Proposed Residential
Development at Howth Road,
Dublin 3

Stage 1 Road Safety Audit

Document Ref: P21-018-RSA-PD-RP-001

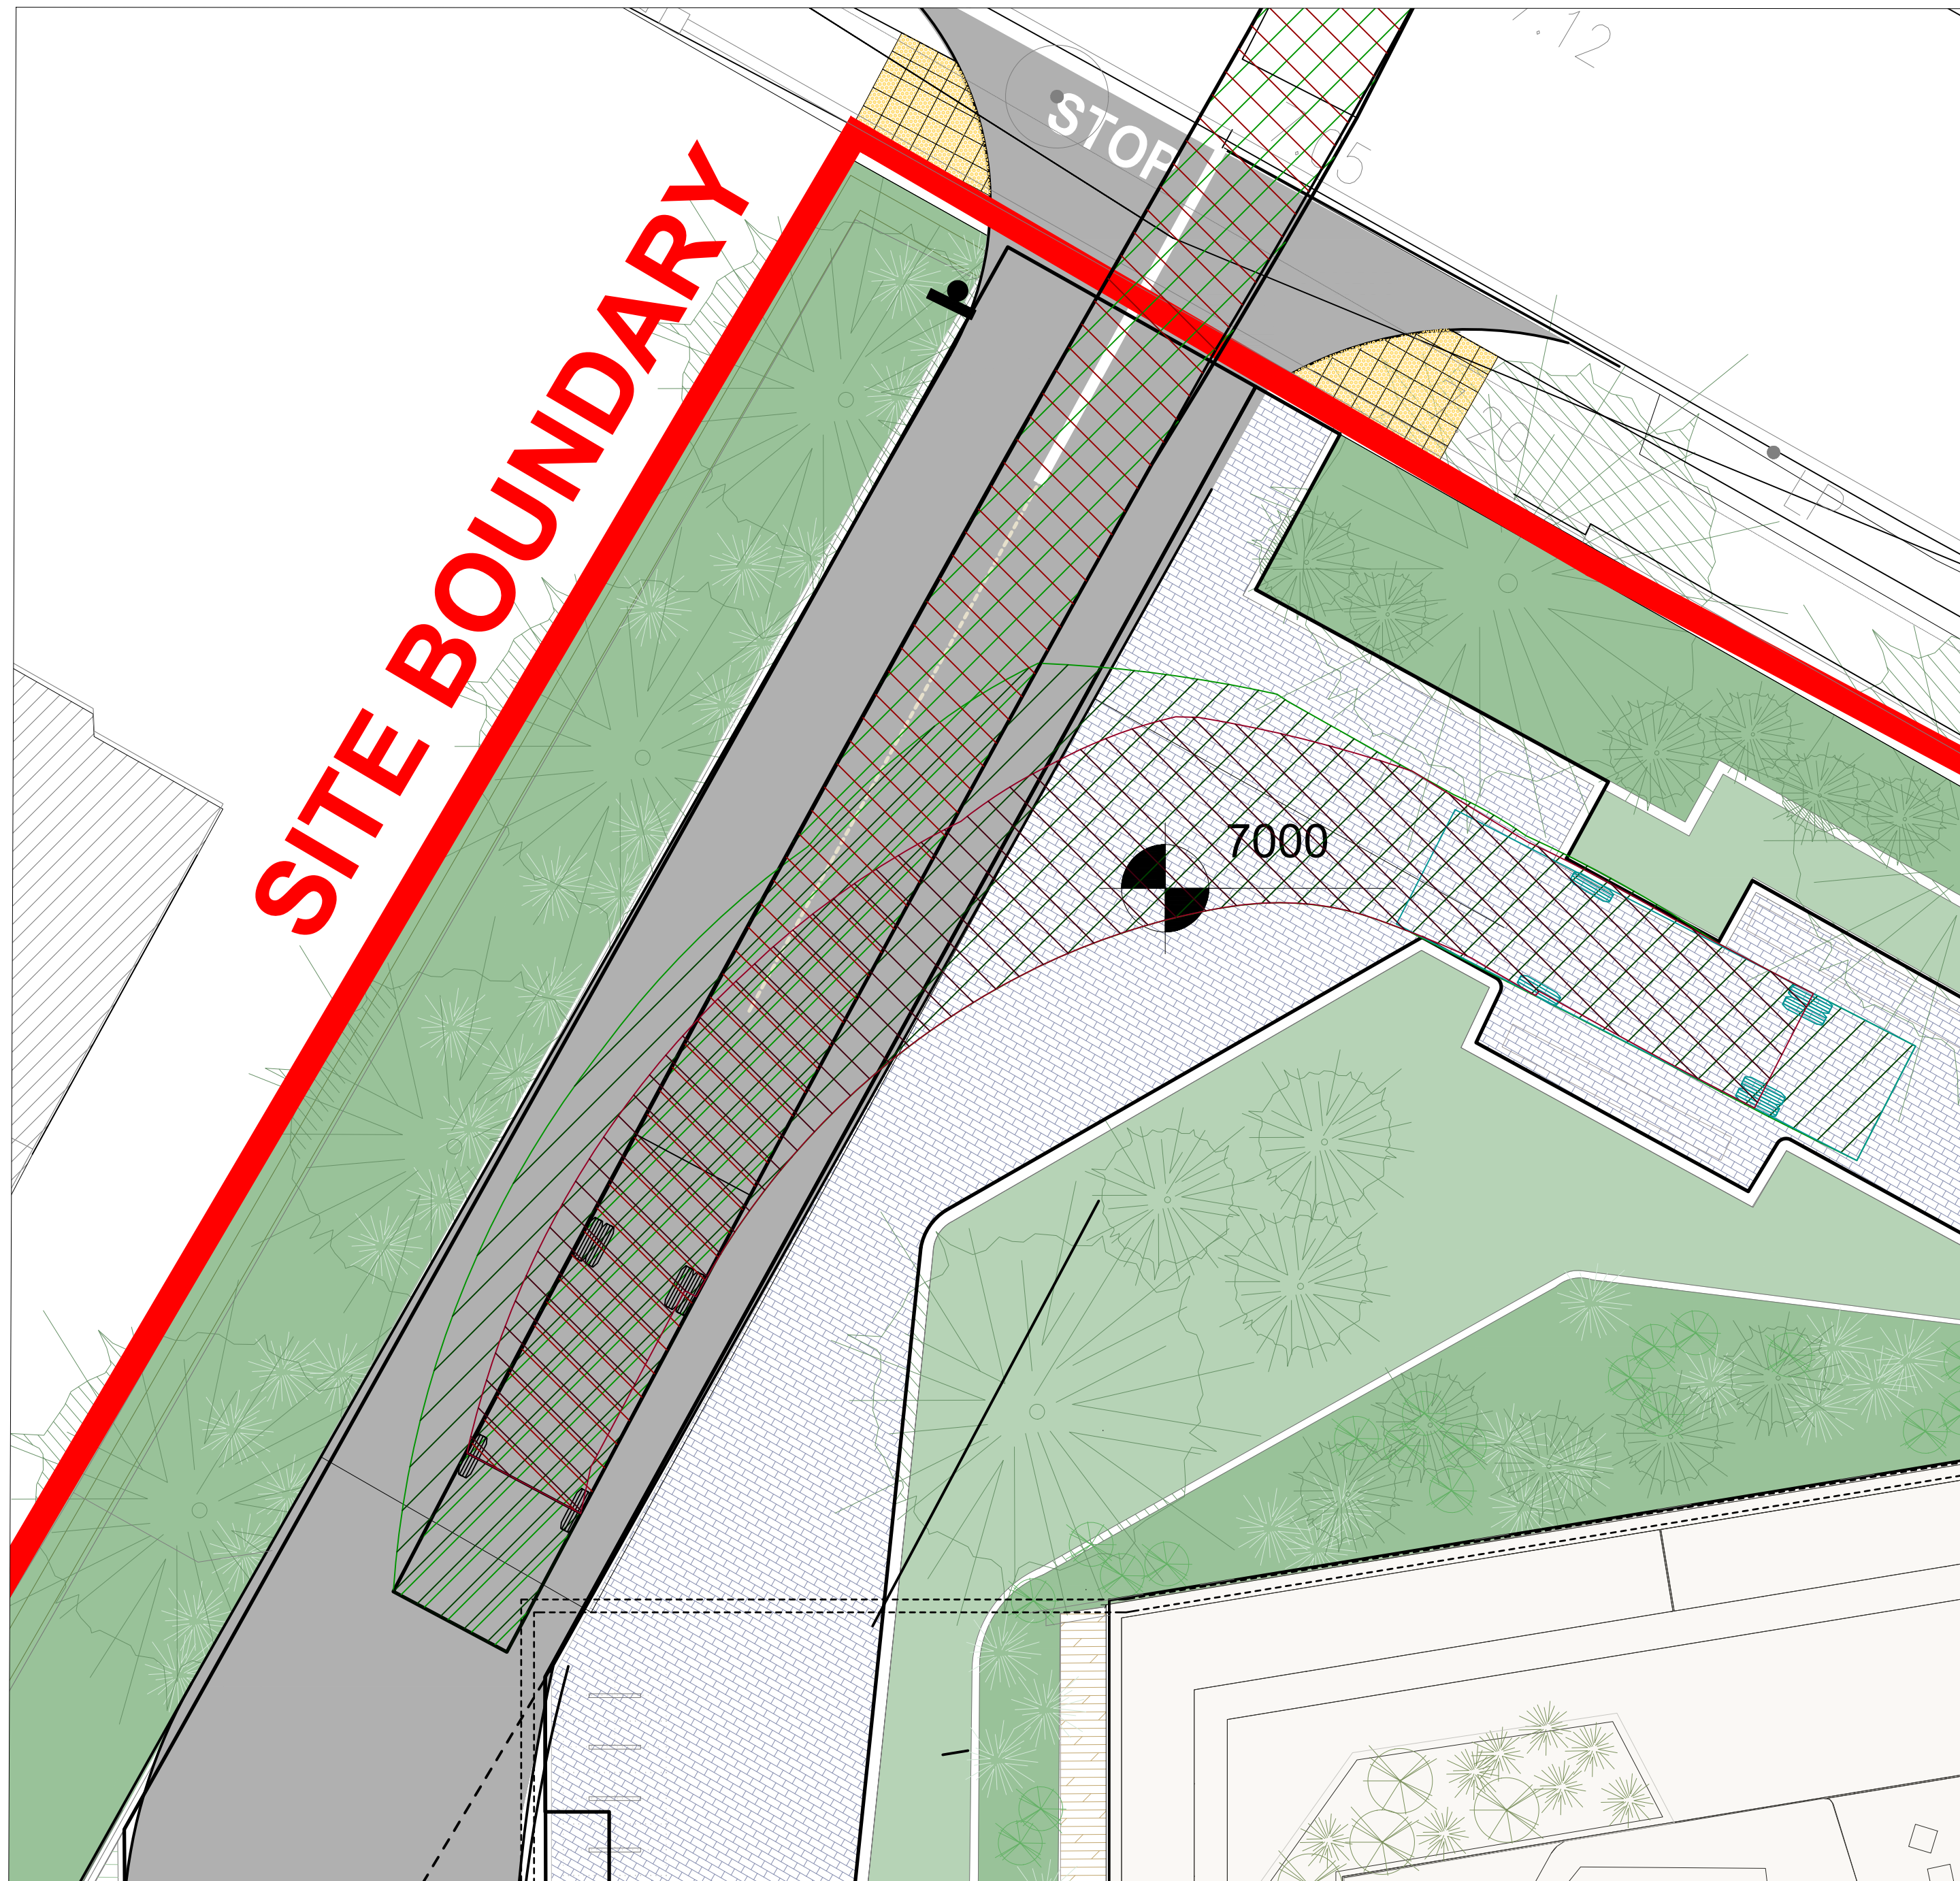
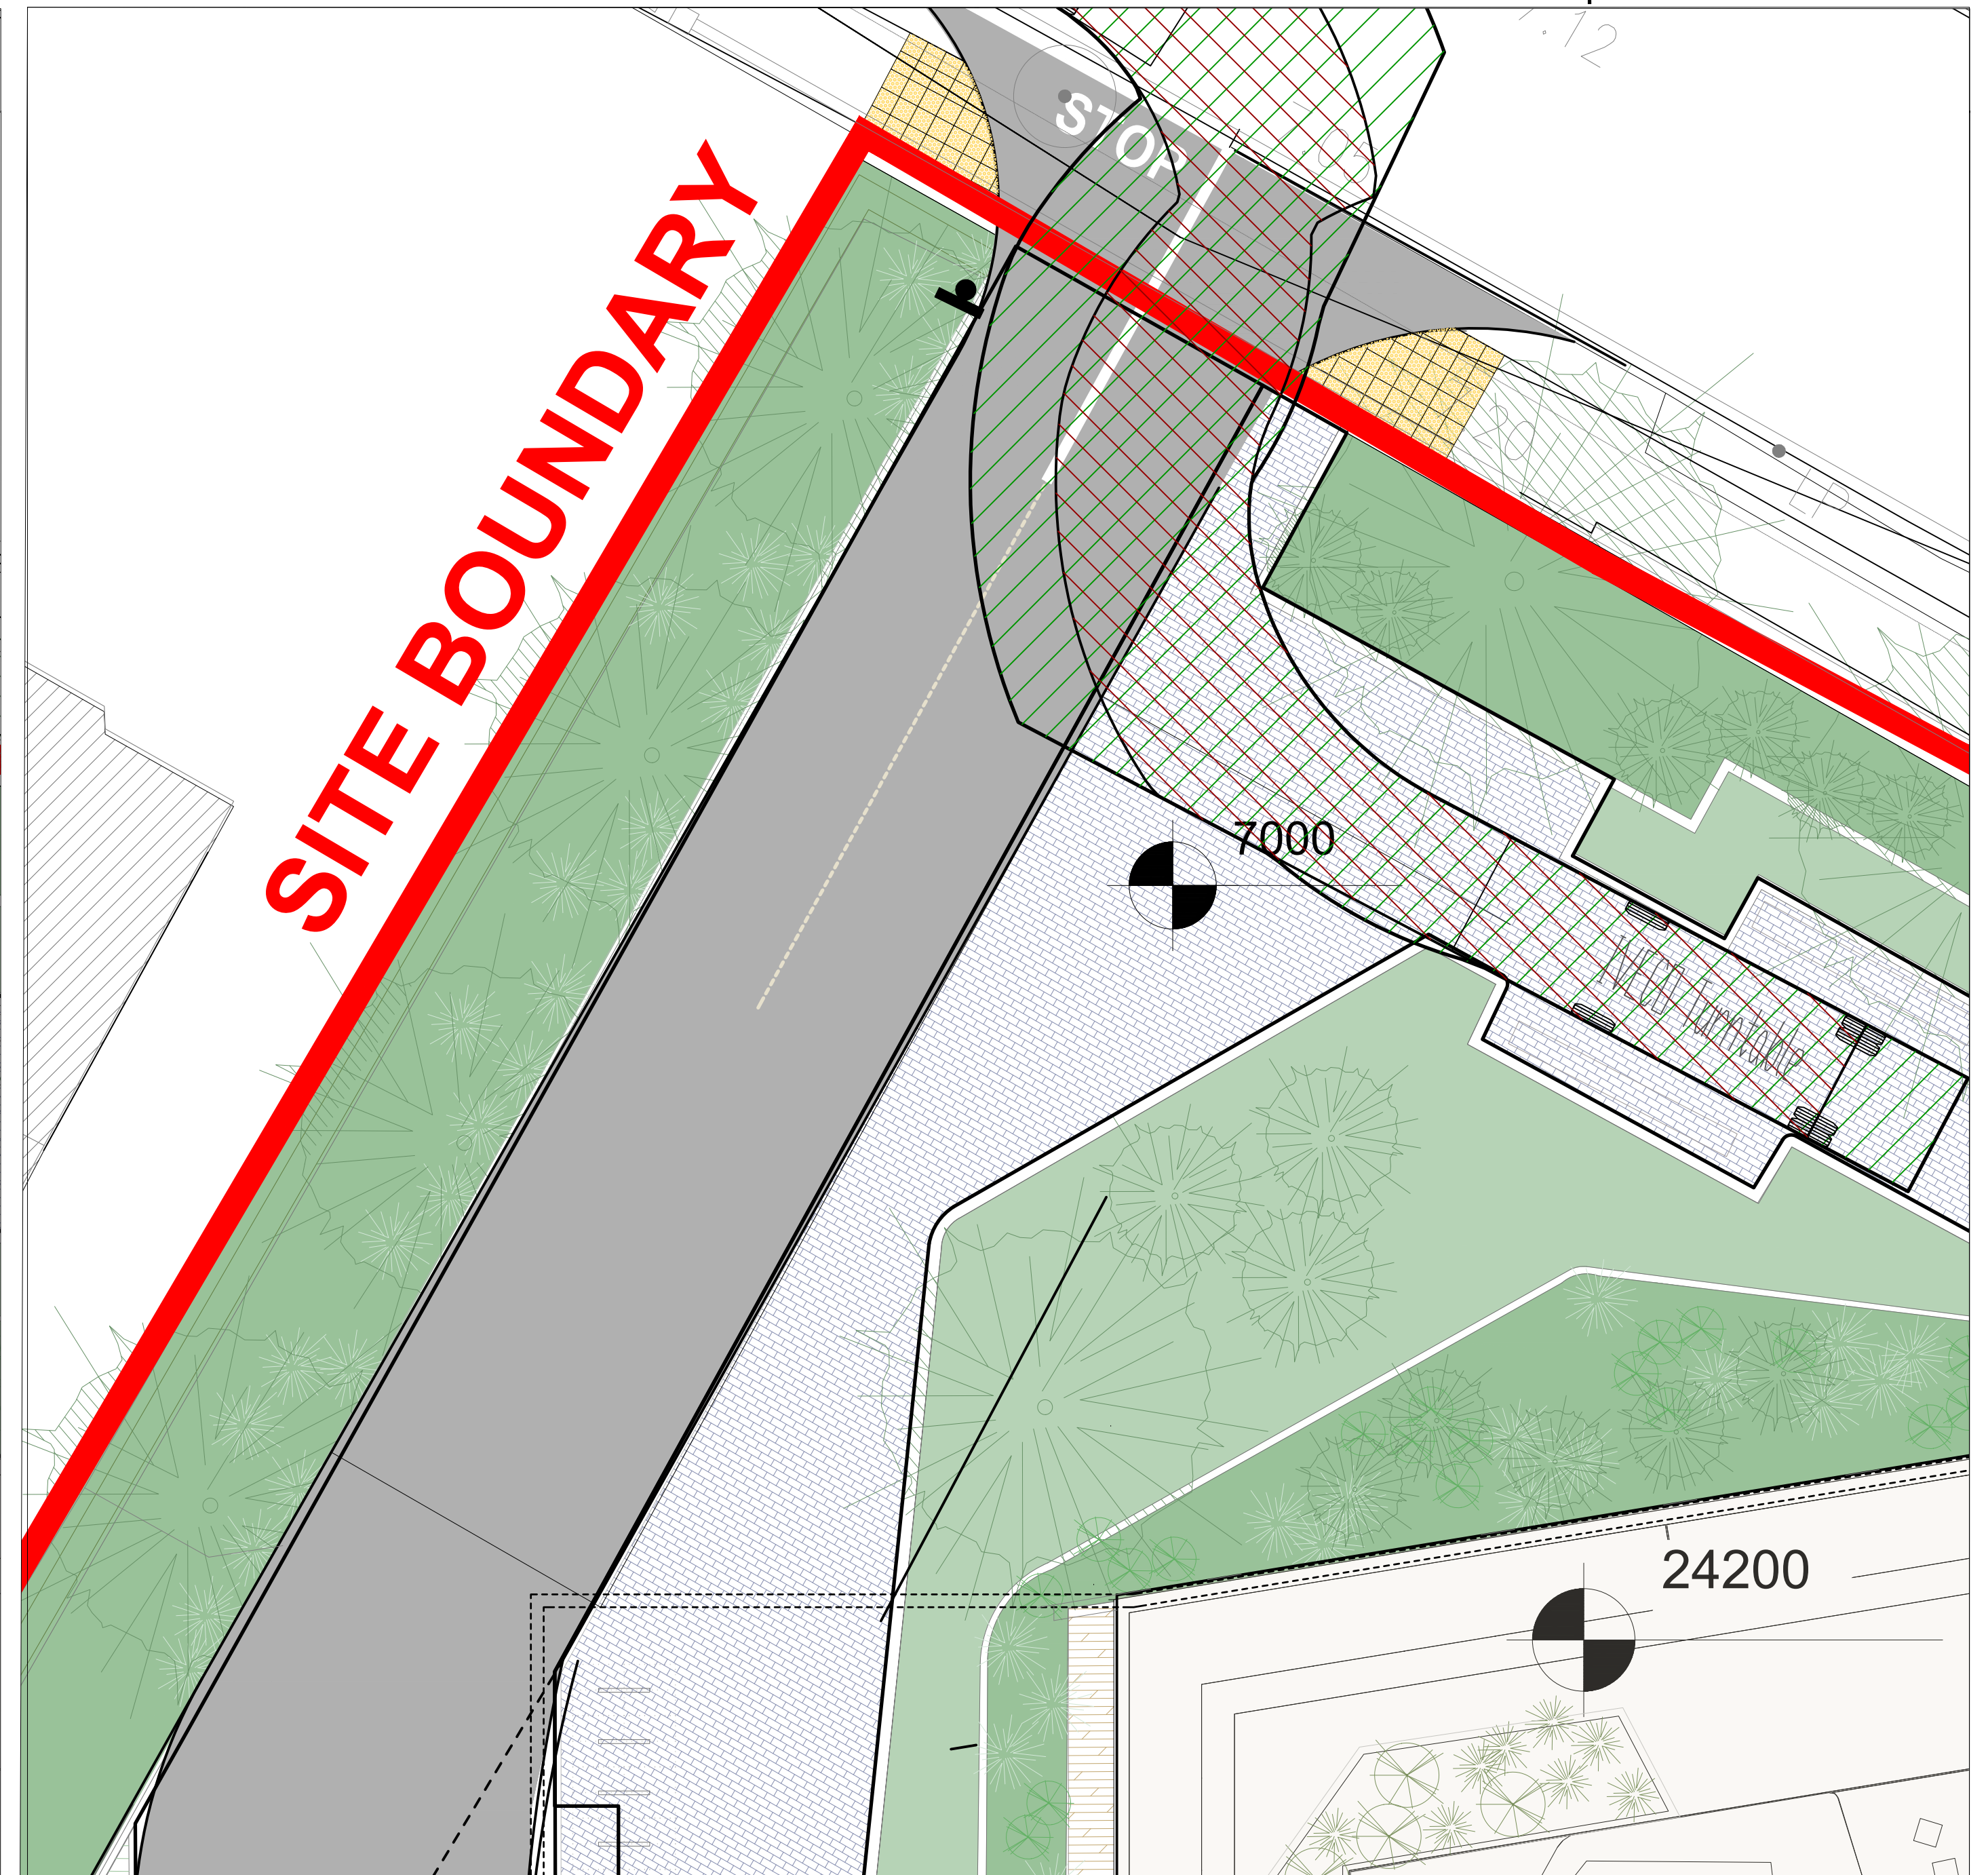
Location: Drawing HOW-BMD-00-ZZ-DR-C1042 (Rev. P4)

Summary: Fire tenders may experience difficulty when travelling in the grassed verge and may reduce the structural integrity of the paved areas within the development.

The swept path for a fire tender within the proposed development is indicated as using the grass verge and pedestrian area when travelling through, and turning within, the development.

It is unclear if the paved vulnerable road user areas will have sufficient structural properties to withstand a fire tender as it undertakes a U-turn manoeuvre. If the pavement is not strong enough to support such loads there is a risk of cracking and structural failure resulting in trip hazards for VRUs.

The 'Grass Pave' area adjacent the top of the basement carpark access ramp should be extended to the rear of the apartment blocks throughout the length of the emergency access route.

Also, ensure the paved VRU areas can sufficiently support the load of a turning fire tender.
